October 4, 2022

Re: Public Comment Overview - File No. 2207-019 / 6950 SE Maker Street / Parcel
No. 9350900620

We are commenting on this proposed project because we believe the GFA calculation and the existing grades designated by the applicant do not comply with the Mercer Island City Code (MICC). We also have several concerns and questions for the City that pertain to the geotechnical and storm drainage report of which we request be answered. Additionally, due to the complexity of the proposed project, site considerations by the geotechnical consultant, and tight confines of Maker Street, we are requesting the City require a Construction Management Plan be filed. And lastly, based upon our understanding, the MICC tree code may have been violated, and we've provided information pertaining to that issue.

BUILDING ELEVATIONS

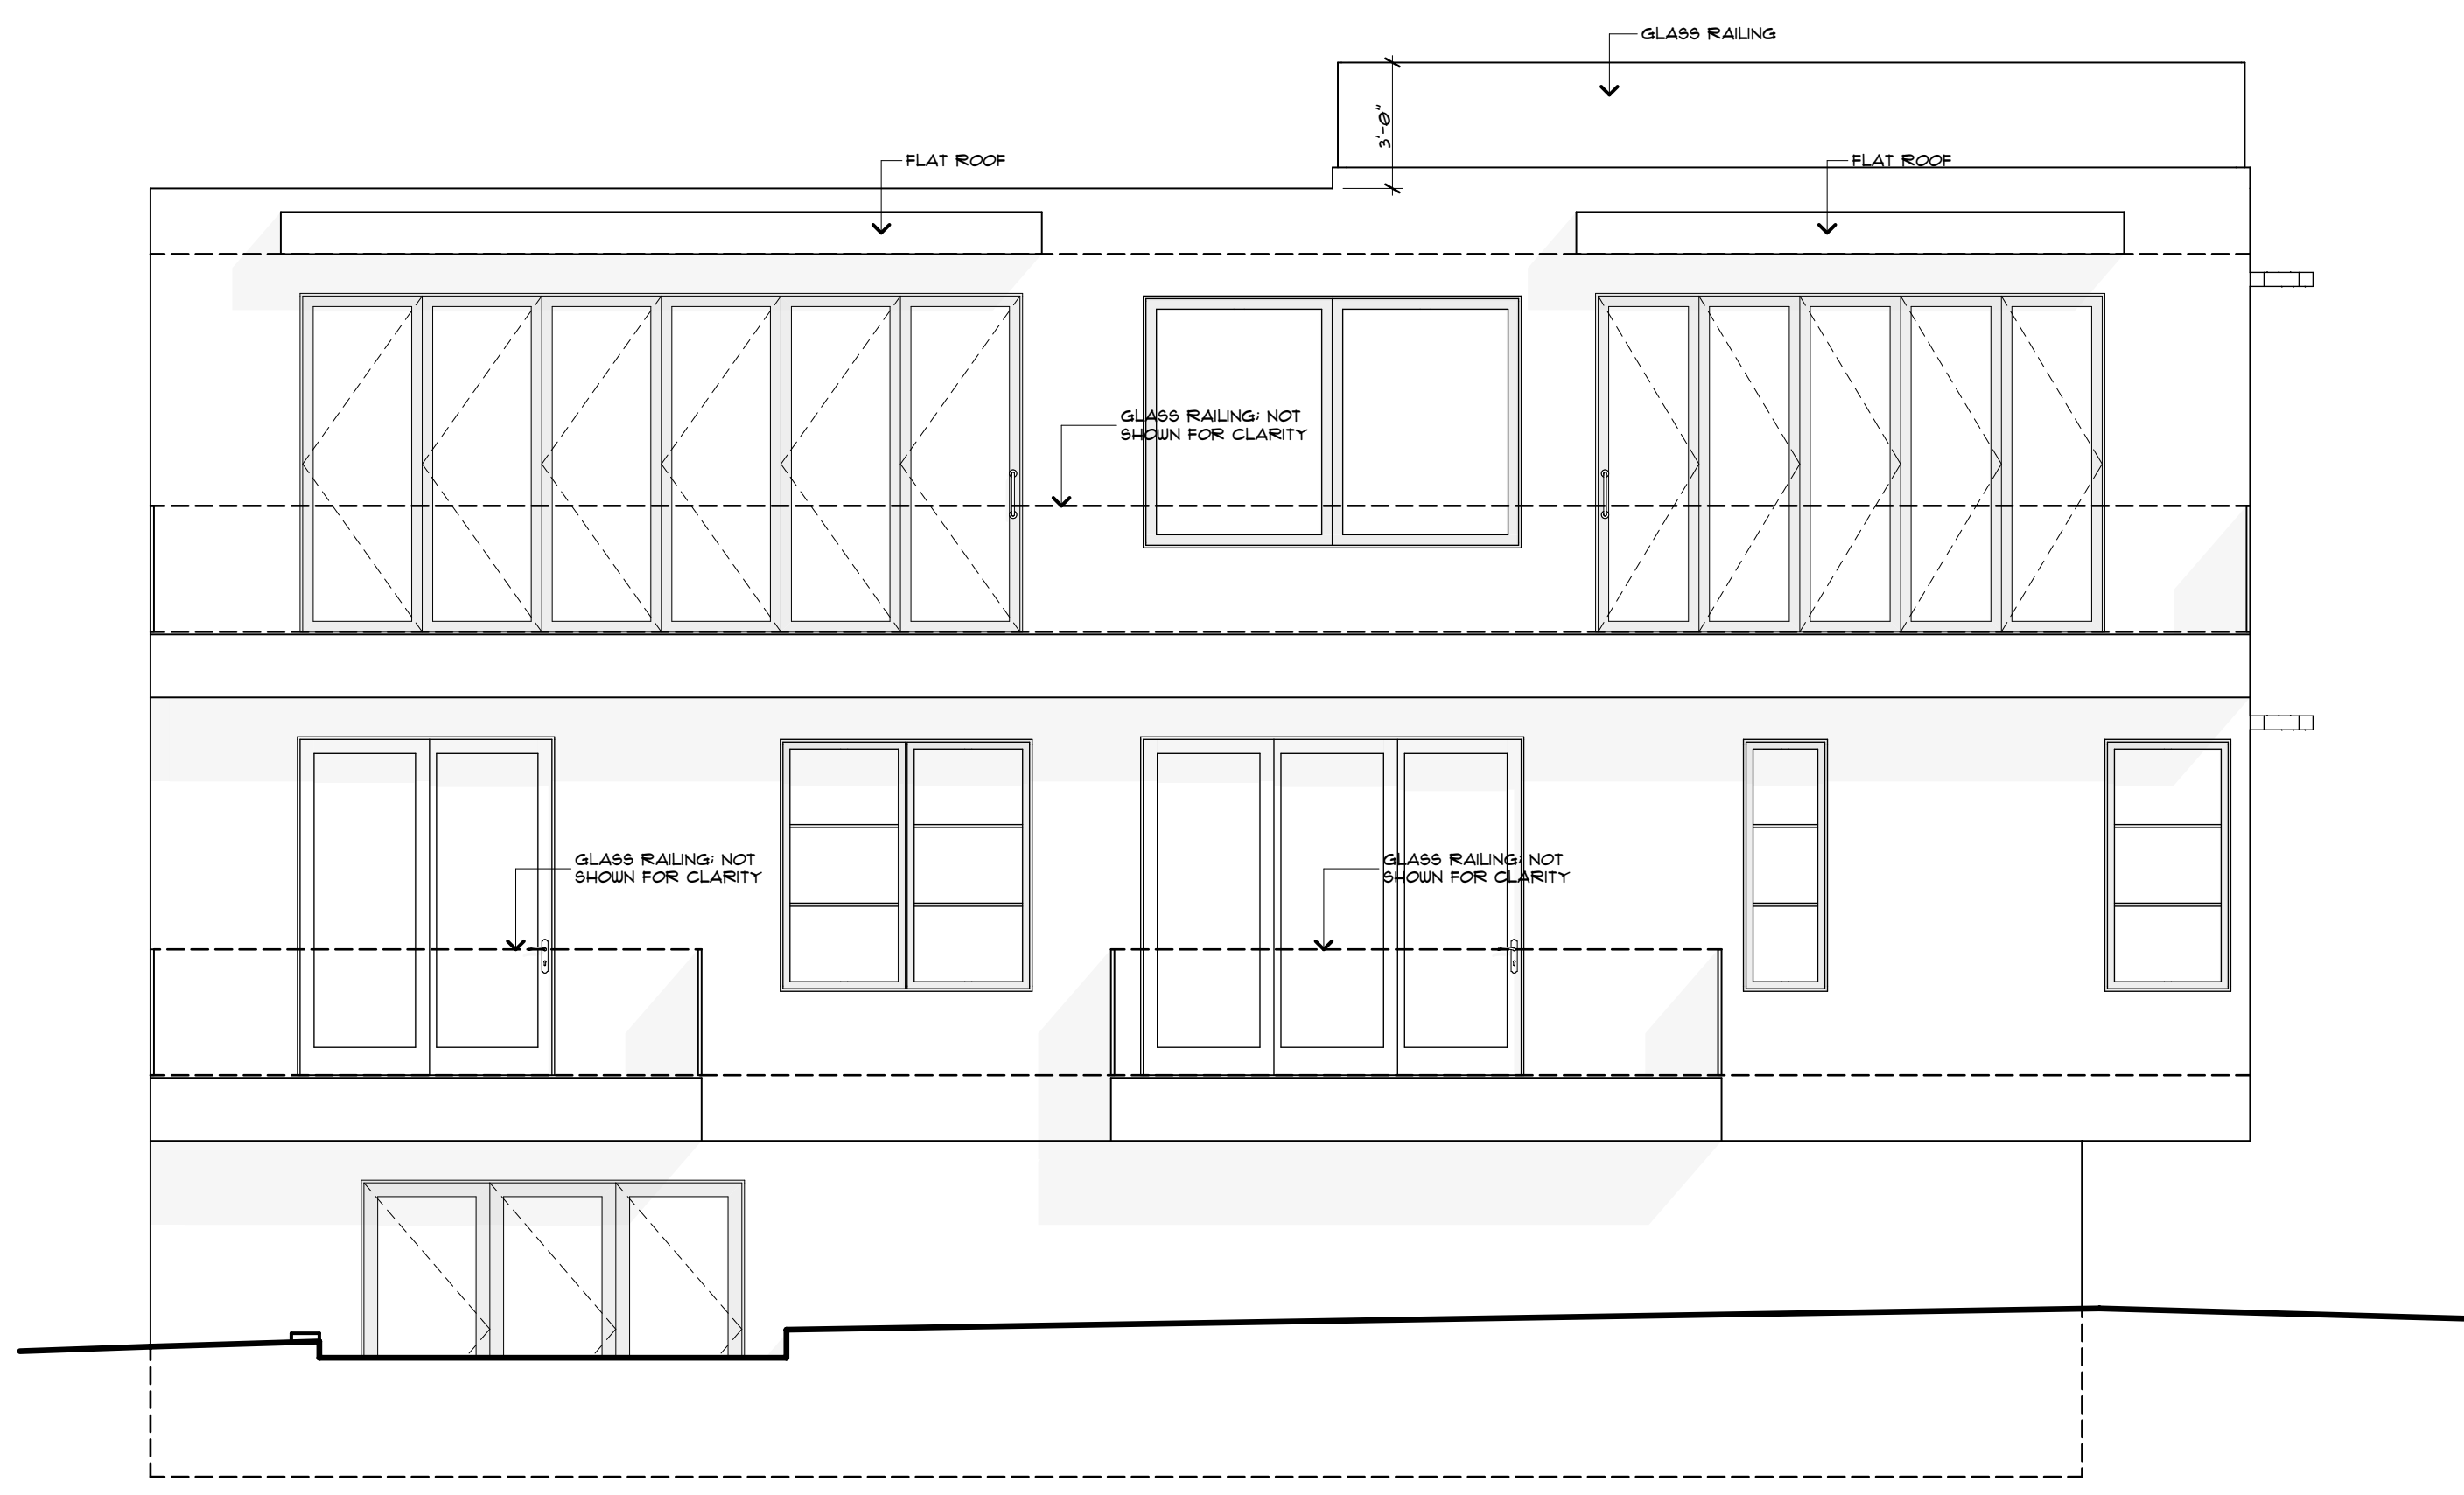
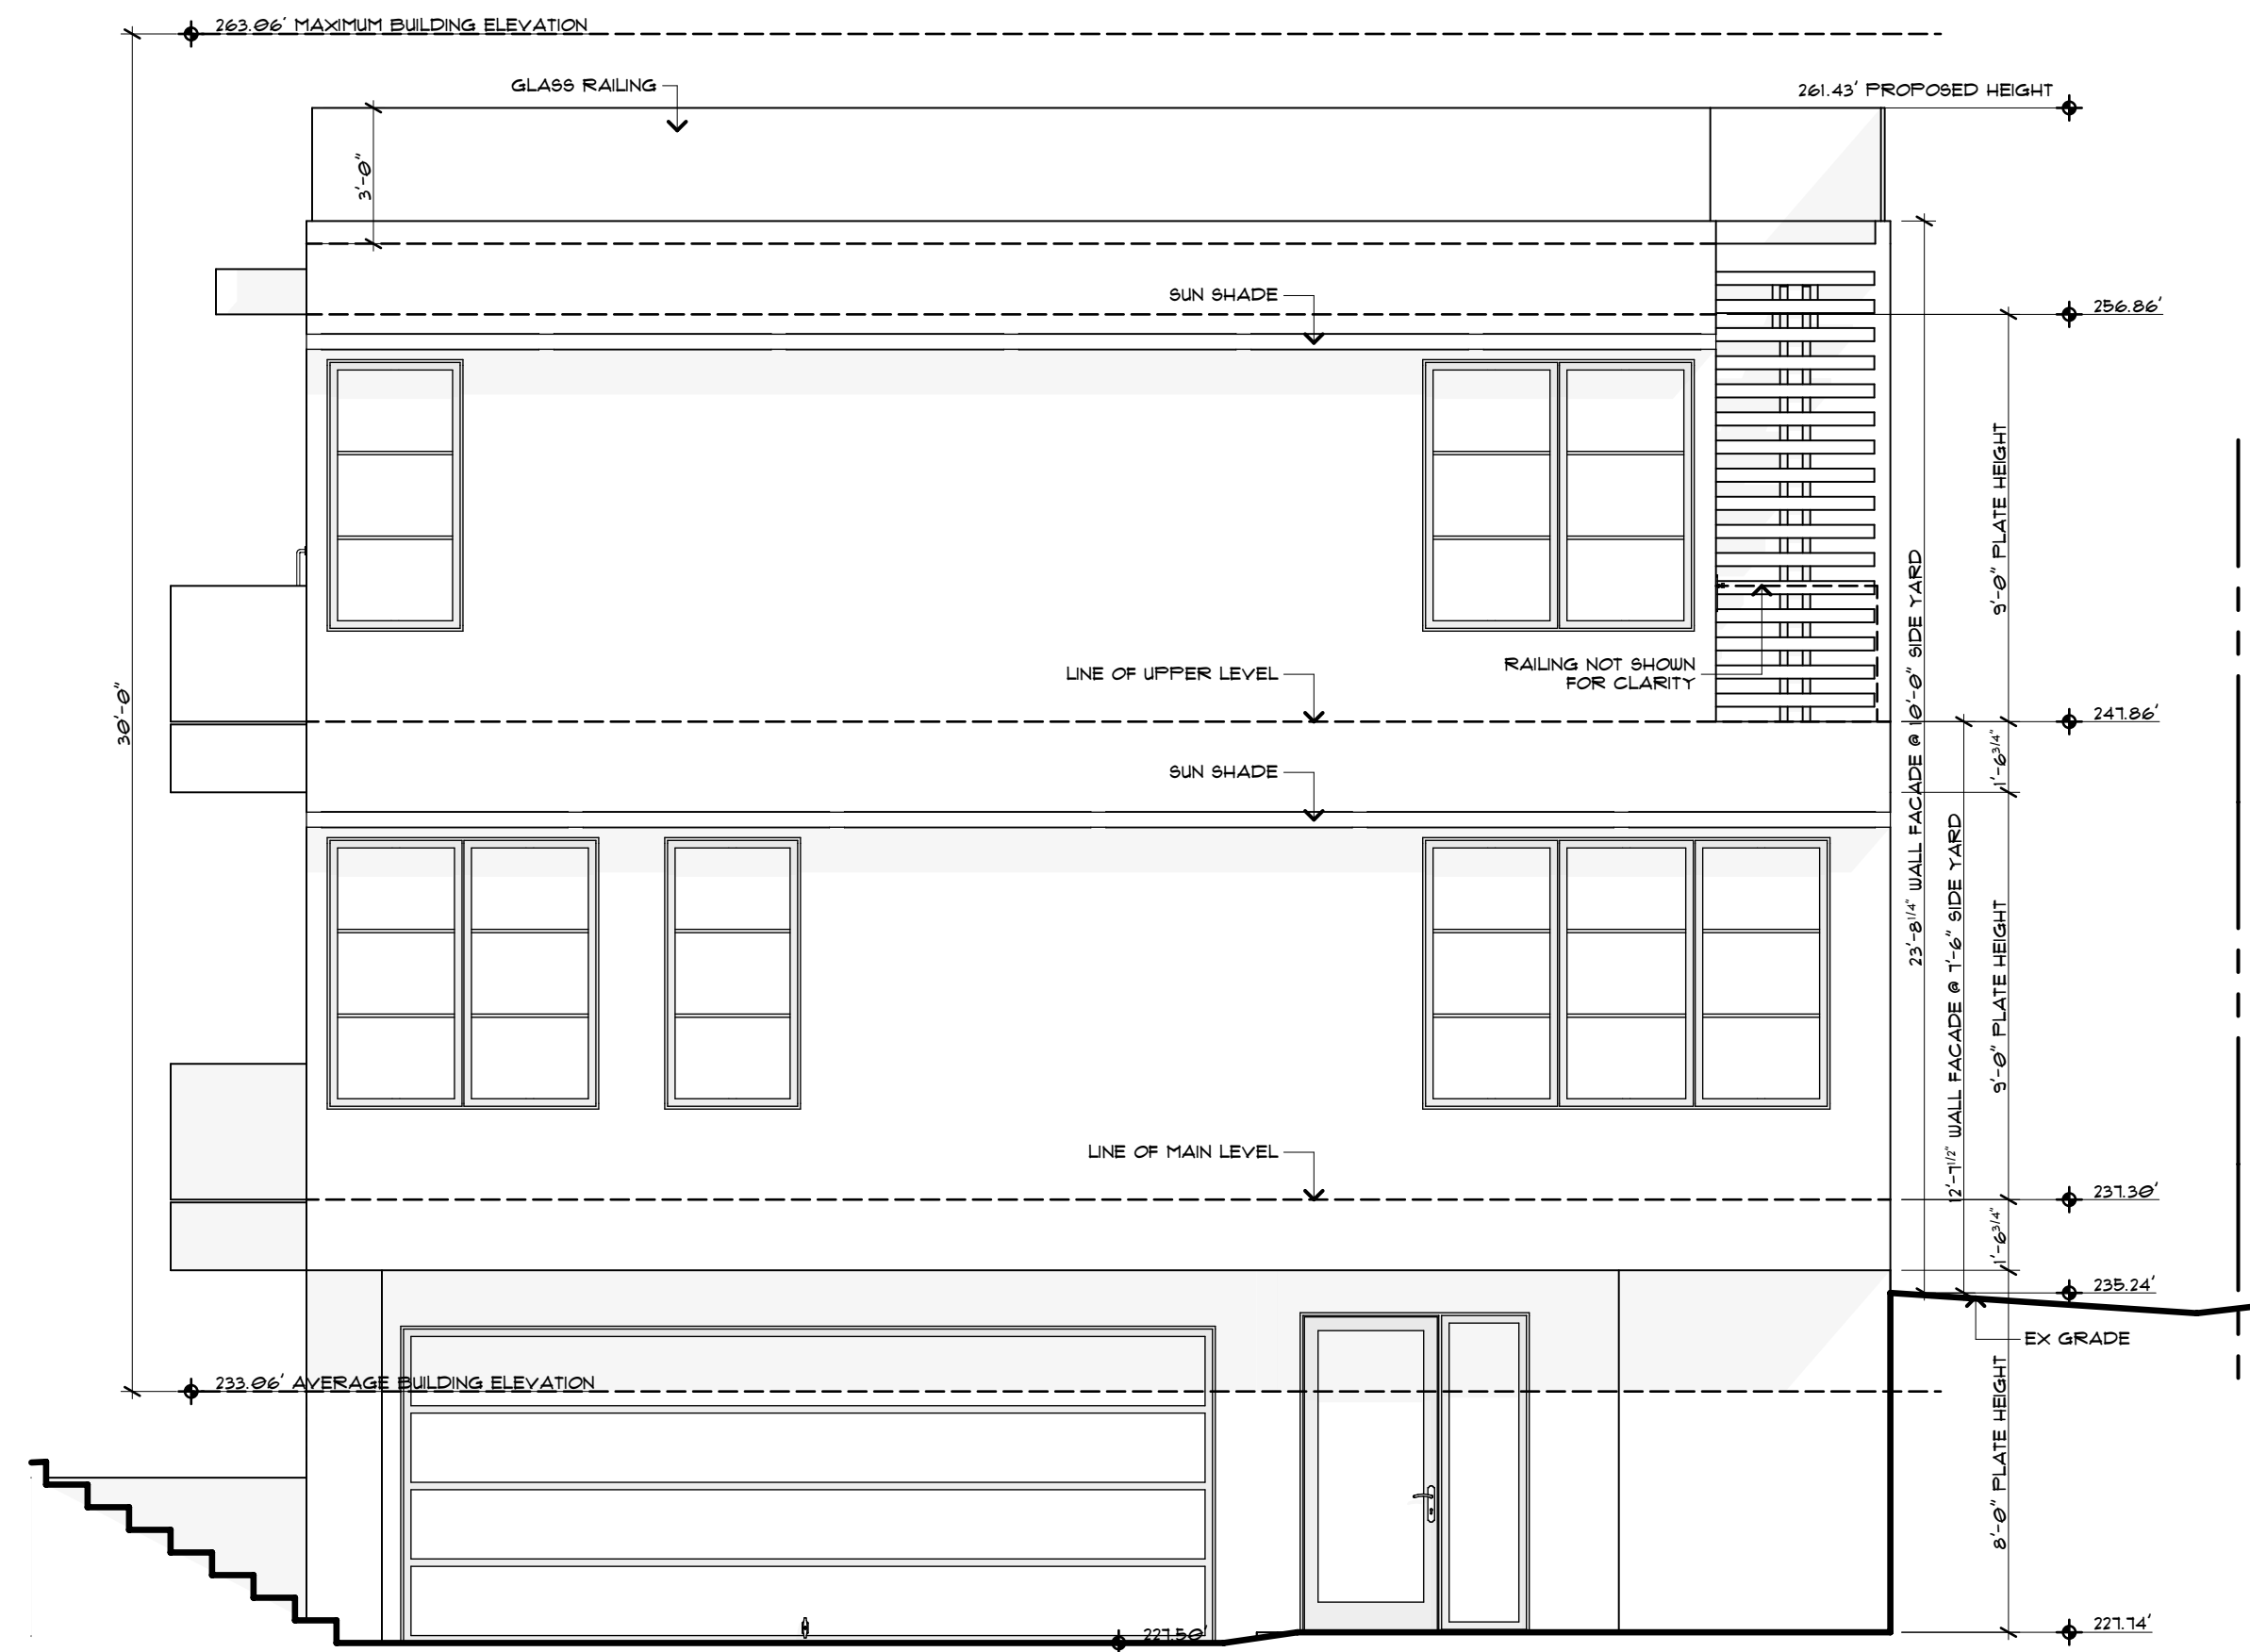
Though the existing grade elevations were not shown on the three of the elevation drawings, existing elevations were used from the survey drawing to gain approximate grades. And where "proposed finished grades" were lower, as per Appendix B - Basement Floor Area Calculation, we used those at the garage front and entry and the basement patio door. A copy of our calculations are included in the attachments.
